DECISION DELEGATED TO DEVELOPMENT MANAGER

Application No: H02-0710-20 **Applicant:** Longhurst Group

Proposal: Details of site levels & floor levels, management and maintenance schedule for landscaping, refuse/recycling & private drives and provision for bird boxes (Conditions 9, 11 & 12 of H02-0078-20)

Location: Land East Of Crease Drove Crowland

Drawn By:	RF	Client	Geda Construction
Chkd By:	TH	Project	Housing Development Crease Drive Crowland
Scale @ A1:	1:250	Title	External Levels Layout
Date:	September 2020		
Status:	TENDER		
Project No.:	11557H	Drawing No:	113
Rev:	D

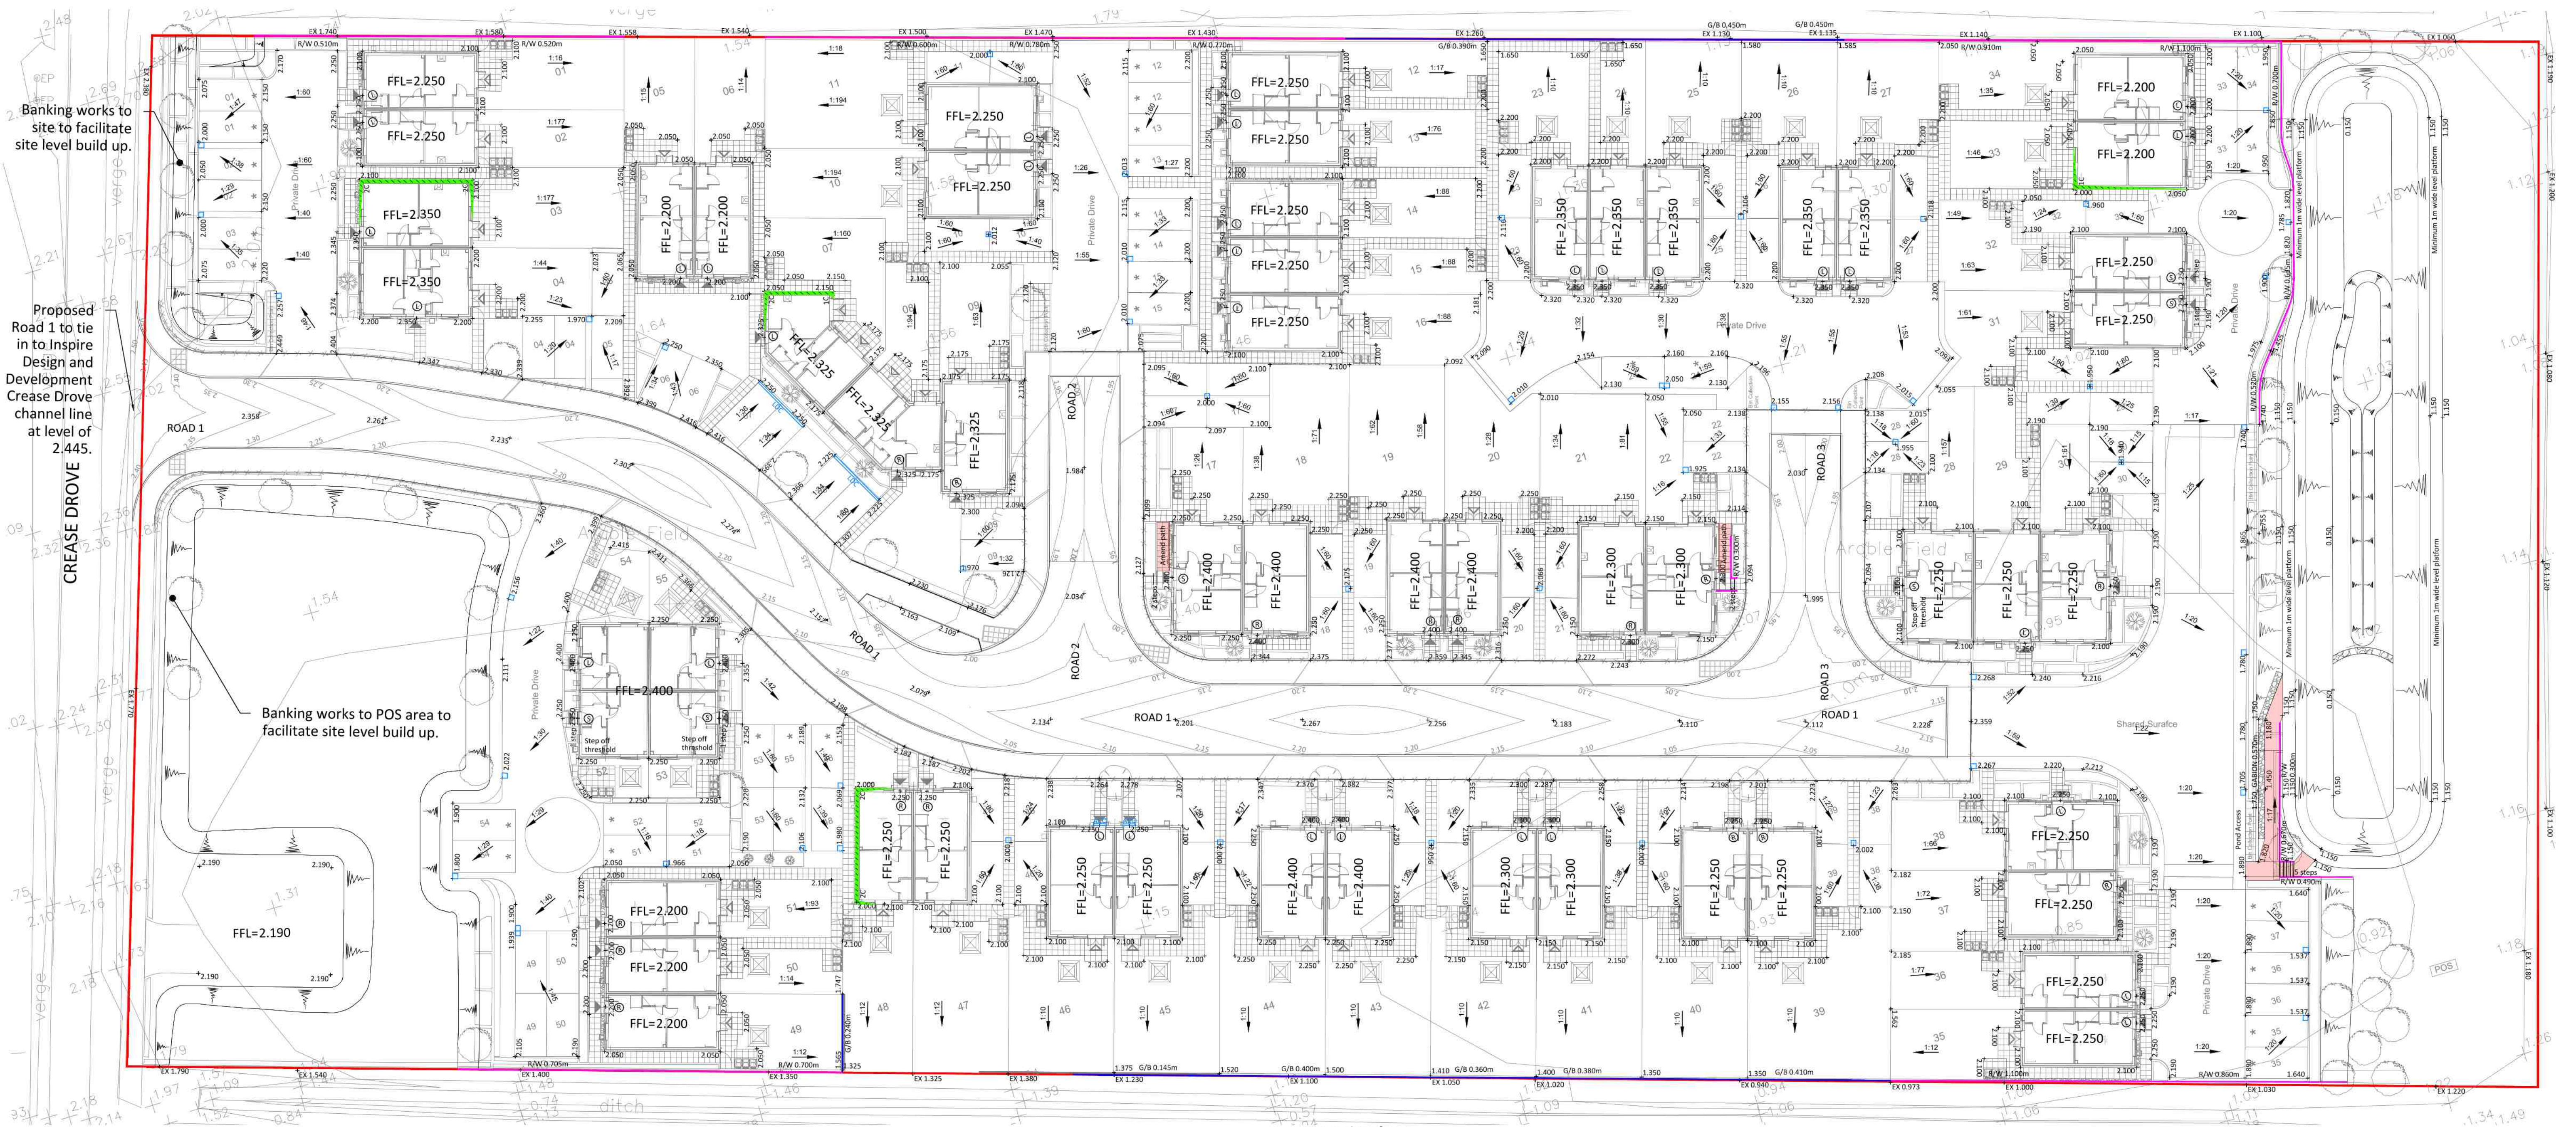
Condition 9 (Details of site levels & floor levels) - Condition 13 of H02-0078-20 requires finished floor levels to be set at a minimum of 2.19m AOD. The proposed finished floor levels comply with this requirement. Patio levels would be 150mm below finished floor levels. Ground levels would only vary marginally across Plots 28-34 with the lowest level being 2.05 AOD at the northern boundary of the site. The patio levels of the closest properties on the site to the south would be approx. 300-400mm lower than those of the closest dwellings on the application site. However, the ground levels on the application site are higher and thus the base of the fencing along the southern boundary will be at a higher level. The same applies with regard to the site to the north in that site levels are similar to, or slightly higher than, the application site. It is therefore not considered that there will be a material overlooking impact between properties. Structural retaining walls would be used on the northern and southern boundaries where required. In light of these considerations, the proposed levels are considered acceptable.
